**Application No:** P/42/22/DOC  
**Registered:** 16th March 2022  
**Site Address:** Land North of Hook Lane Pagham PO21 3PD  
**Description of Works:** Approval of details reserved by condition imposed under P/30/19/OUT relating to conditions 5-schedule of materials and finishes, 10-surface water drainage, 11-discharge flows to watercourses, 12-maintenance and management of surface water drainage system, 14-foul drainage system, 15-external lighting, 16-Construction Management Plan, 22-existing vehicular access onto Sefter Road and Pagham Road have been physically closed, 23-plans and details and timetable for installation of dwellings, 24-pedestrian and cyclist access points, 27-Broadband provision, 29-enhancement of existing hedgerows for use by bats and 33-Electric Vehicle Charging Strategy.

Please find below our comments on the proposed planning application reference: **P/42/22/DOC**

Please find below our comments on the proposed planning application reference: **P/68/22/DOC**

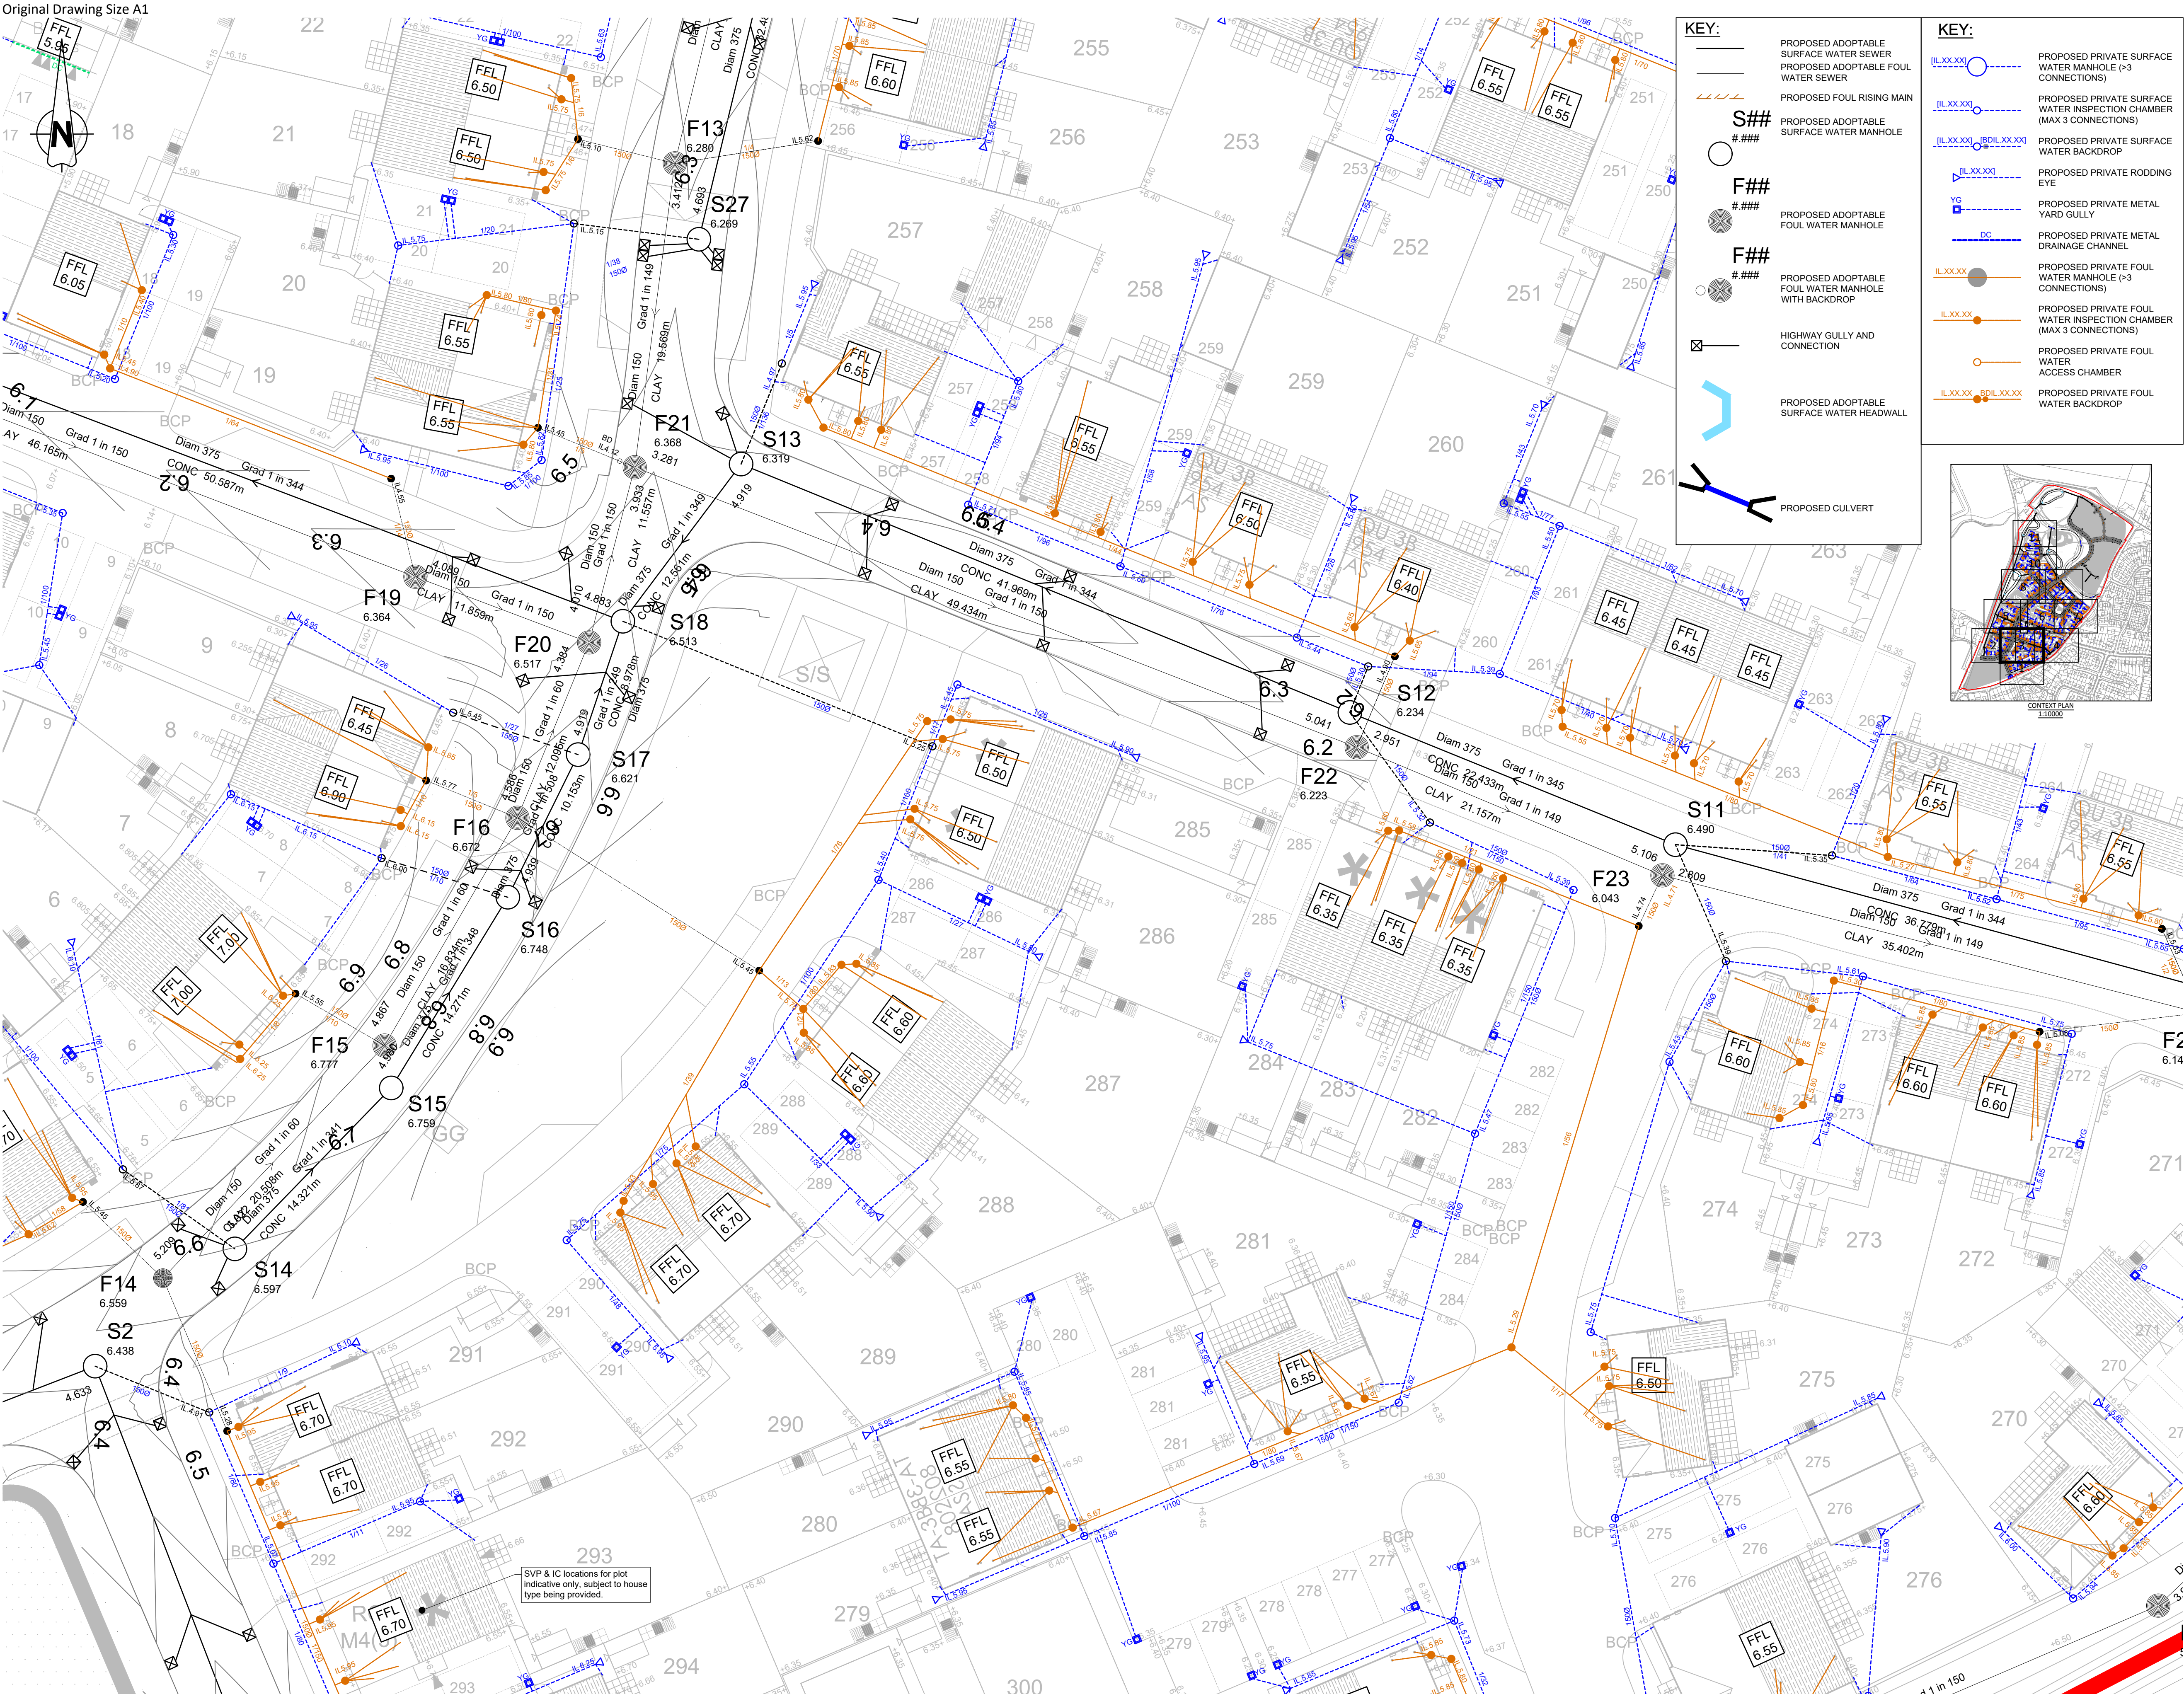
- 1) The existing drainage infrastructure to the southeast of the development site (gully mentioned in Section 4.19 of the FRA) has not been investigated in full. Particularly MH S7 and MH S21.

- The topographic survey does not confirm the inlet diameter of the drainage system from further up in the catchment. Therefore, it cannot be confirmed that the proposed 450mm diameter culverts will be sufficient to manage flows through the site. If inflows are greater than flows through these culverts, the design of the realigned channel may need to be revised so that additional flows can be conveyed safely through the site without increasing the risk of flooding onsite, or to the northeast (by the existing cottage).

- 7) We note that the ‘sump available’ option has been selected as yes in the drainage calculations. If a Hydro-Brake with sump available is specified, as is indicated by the calculations, this sump will need to be included on the drainage drawings.

- 12) Bespoke details for unique structures should be provided, e.g. the headwall for the culvert and basin outfall, located at MH S119. Detailed drawings of these will be required. The applicant should consult our checklist for further details expected for DOC applications, which require full detailed construction drawings and specifications to be provided for the entire proposed drainage system. [Drainage Planning Consultations | Arun District Council](#).

- 14) Cover levels need to be included on all manholes and the type of manhole should be label so that it can be identifies on the drainage layout drawings and cross sections.
